**Consultation Response from Emma Mills
KC Landscape**

Application No:	2021/94280
Proposed Development:	Erection of 67 dwellings with associated works
Location:	land at, Lady Ann Road, Soothill, Batley, WF17 0PY
Applicant/Agent:	Self Architects
Planning Officer	Nick Hirst
Date Responded:	16.12.21 rev and highlighted 22.12.21
Responding Officer:	EM
Responding Ref:	KK139

Lady Ann Road
Topia Landscape Architect
 Quote No.5002215
 Dwn DB Scale 1:100@A1 23.09.2021
 Do not scale from this drawing

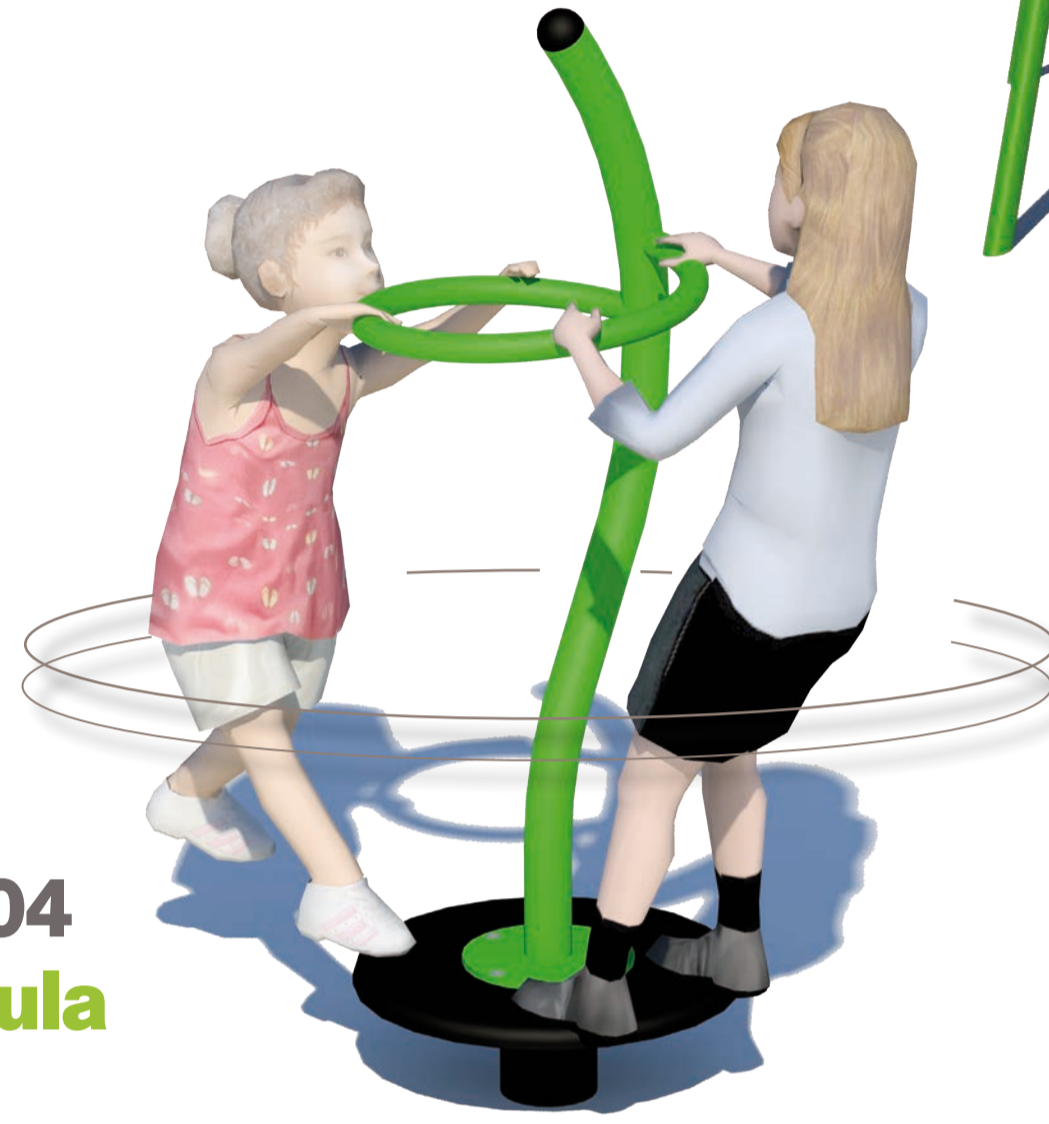
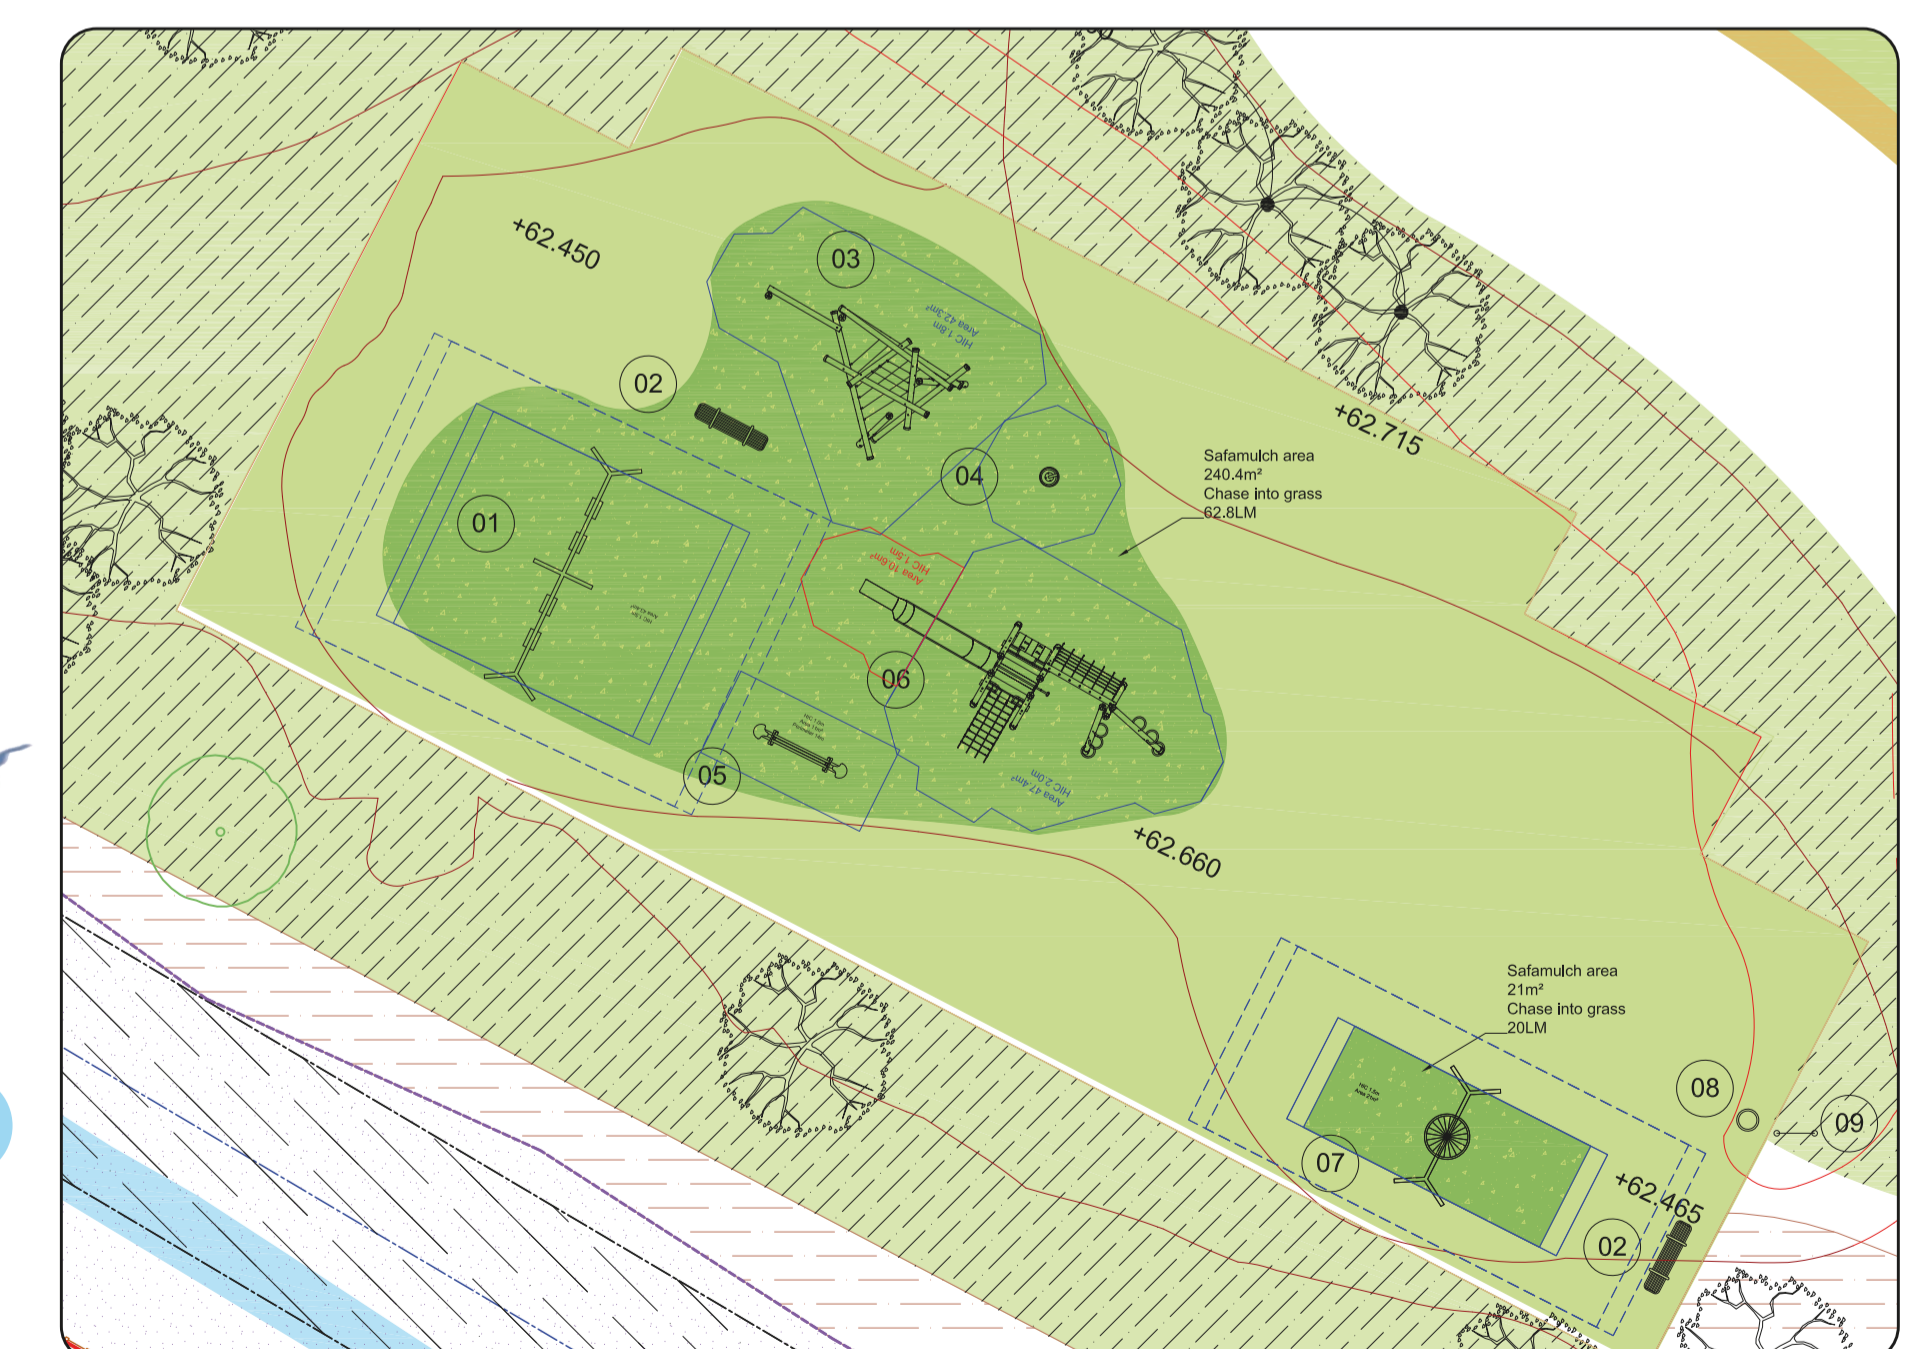
1. is it possible to install this play area OVER the attenuation tank as some of the footings for the play items require large concrete foundations?
2. Will there be inspection covers protruding through the safety surfacing?
3. Will it be fully meet BS EN 1176 & 1177 over an attenuation tank?

Play area layout – not sure this is the final design or indicative. A couple of queries about siting and location of proposed benches and equipment, this bench is in potentially blocking half of the access path.

Bark is shown as the safety surface – has DDA accessibility been considered? Bark is difficult to push wheelchairs and push chairs across, some more accessible areas would be beneficial to encouraging use by all abilities. There is a potential for this play area, with its play bark surface, to suffer in terms of useability due to potential poor drainage or becoming waterlogged in extreme wet weather being located adjacent to the Beck. Wear pads will be required under the swing, slide, see-saw, roundabout, etc.

Why is there such a large area of empty bark? Could this be a grassed informal kickabout area?

Good range of pieces of equipment included, compliments the offer in the vicinity, however, we would recommend this is metal play equipment in this location for durability (one of the pieces looks like a timber log stack climber with nets – is there a metal version?). Equipment appears congested in one area to the south – is there a reason for this?

No surfaced link path to the community growing area indicated – needs to be accessible as far a practicable for widest use by people of all abilities.

Slide ideally shouldn't be pointing S/SW due to heating up in the summer.

Natural playful elements such as boulders are welcomed, perhaps need connecting into the playable space and features a little? Used for linking other natural features or equipped play elements?
